CITY OF ALBUQUERQUE

August 27, 2008

Re: Comfort Suites, 2411 Central Ave. NW, Grading and Drainage Plan Engineer's Stamp dated 6-27-08 (J12/D026)

TRAFFIC
CIRCULATION
LAYOUT

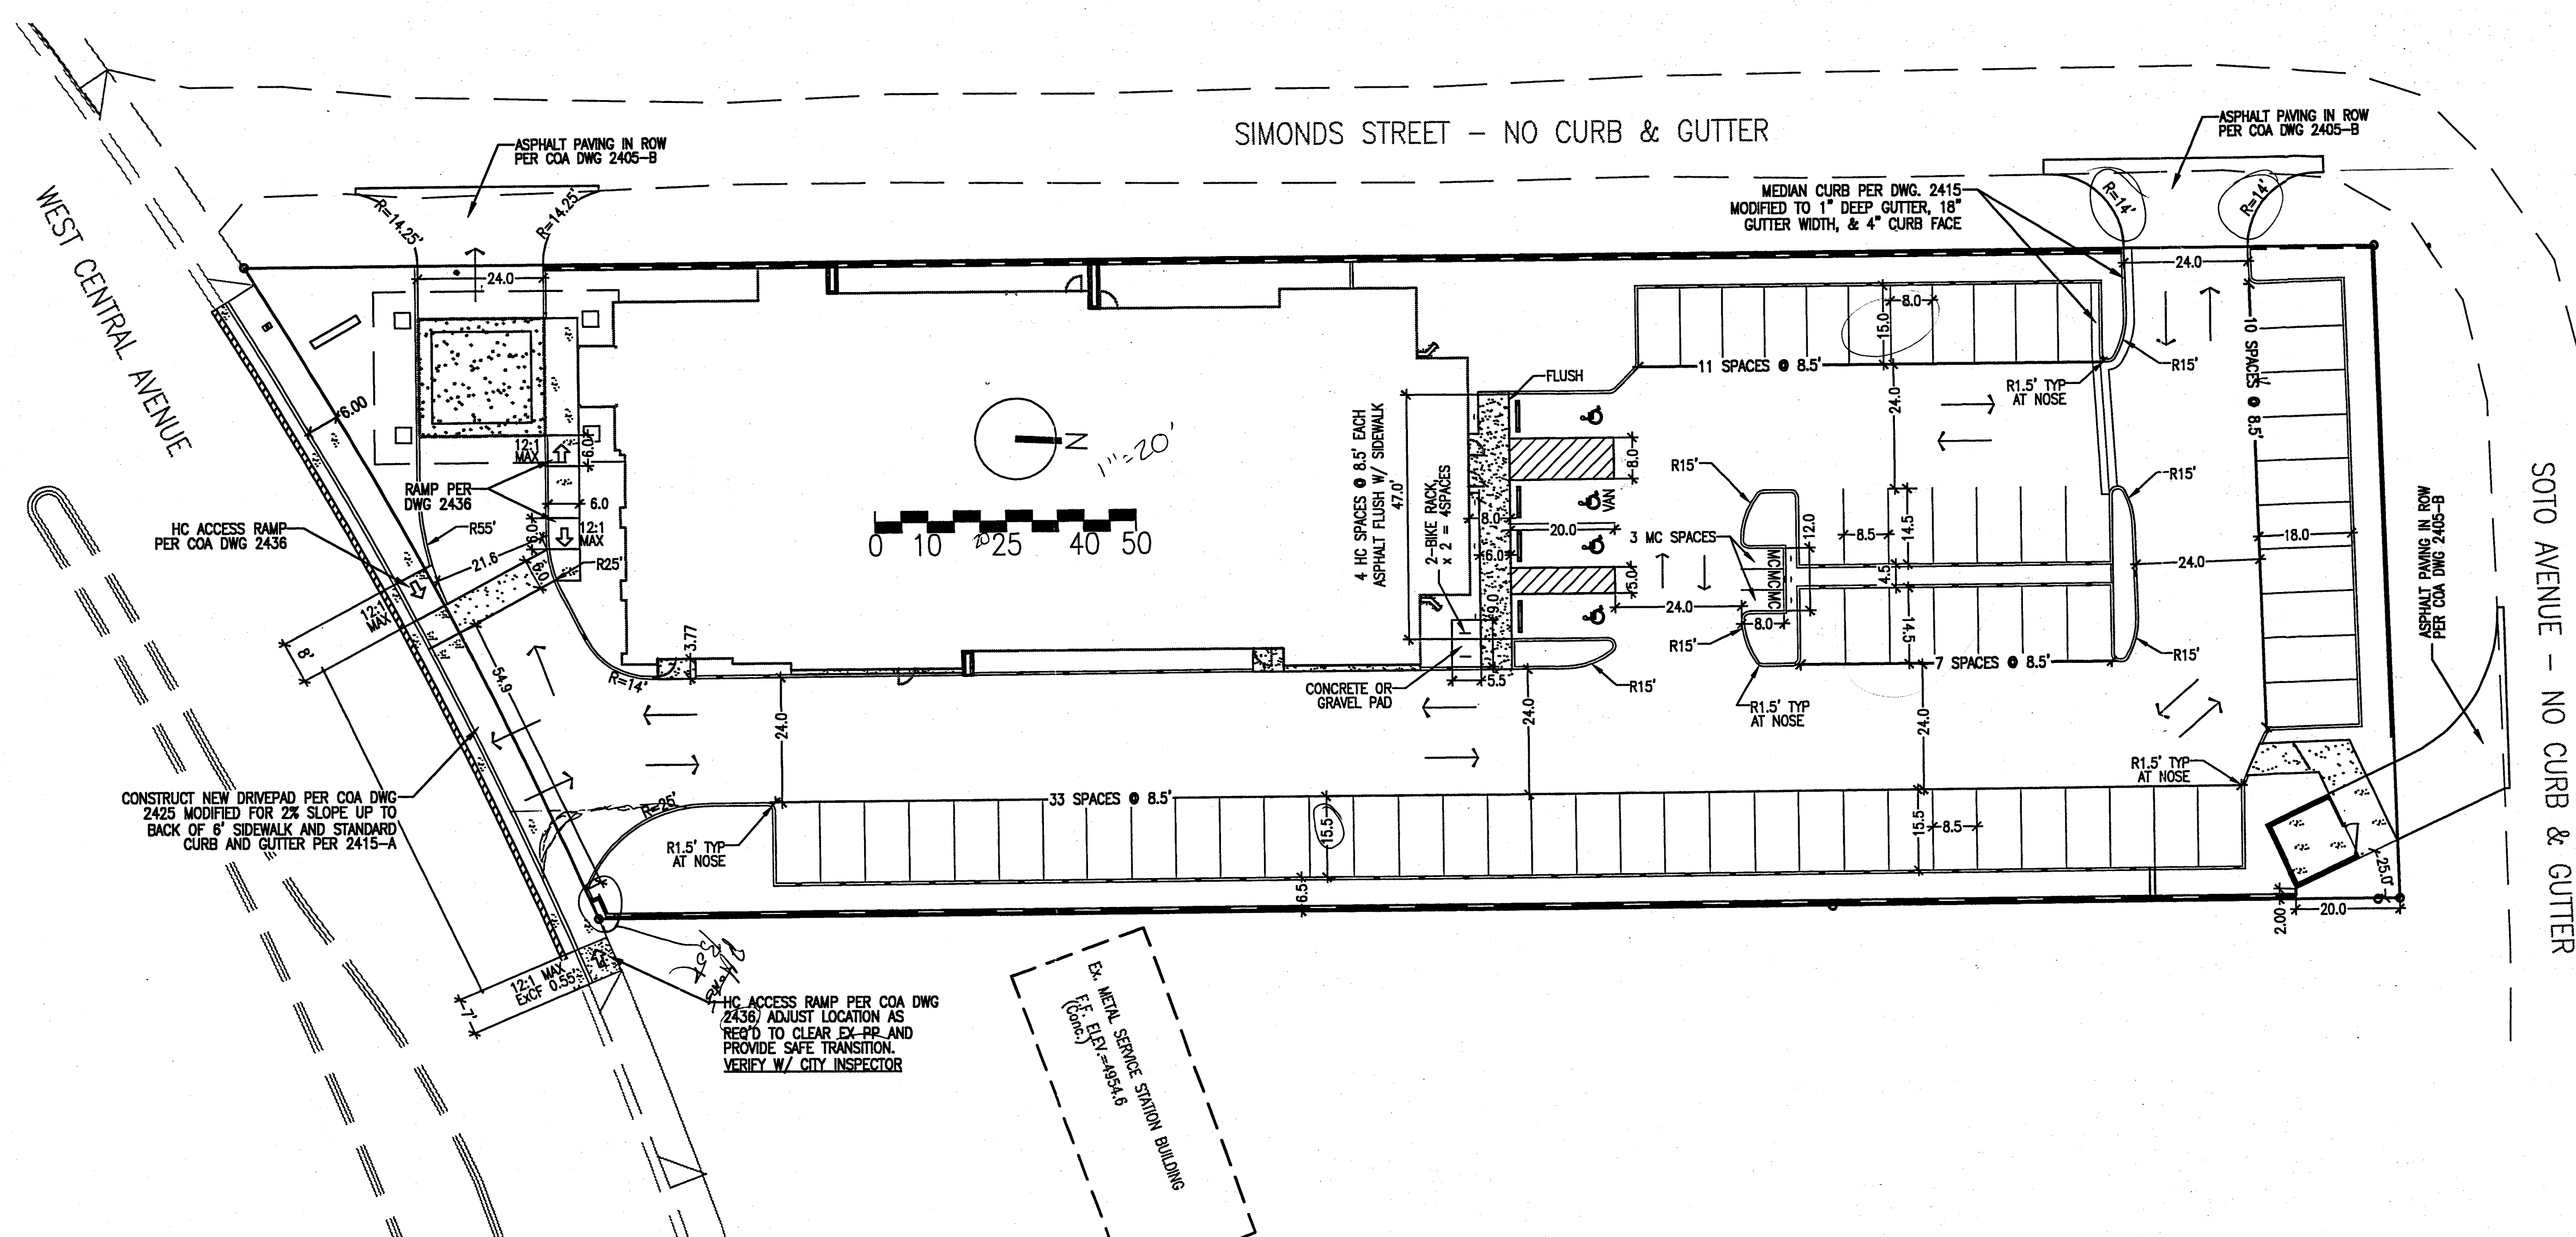
- 2. When the premises contain more than 20 spaces, up to one third of those spaces can be compact car spaces. Therefore, this site has more compact parking spaces than permitted.

- 3. Label the compact parking spaces by placing the words "compact" on the pavement of each space.
- 4. Adequate signage or striping is required for the one-way drive.

- 5. Per Chapter 23, Section 6, Part B.5 of the *DPM*, any drive on a local roadway that is intersecting with an arterial roadway must be located a minimum of 50 feet from the intersection.

- 6. The drive off of Central is too wide and will need to be narrowed to approximately 35 feet in width.
- 7. Drives must be located at least 20 feet from the property line on an arterial roadway. See the *DPM* Chapter 23, Section 6, Part 4.

- 8. The minimum radius for curb returns on an arterial roadway (Central) is 20 feet.
- 9. The minimum radius for curb returns on a local roadway is 15 feet.

- 10. Check and define the site distance for the northern most drive.

11. Standard parking stalls need to be 16 feet in length with a two-foot overhang or 18 feet
- in length with no overhang.

12. All work within the City Right-of-Way must have build notes; refer to the appropriate
- 12. All work within the City Right-of-Way must have build notes; refer to the appropriate City Standard. Please note that, as this site has no curb and gutter, a modified detail will be required.
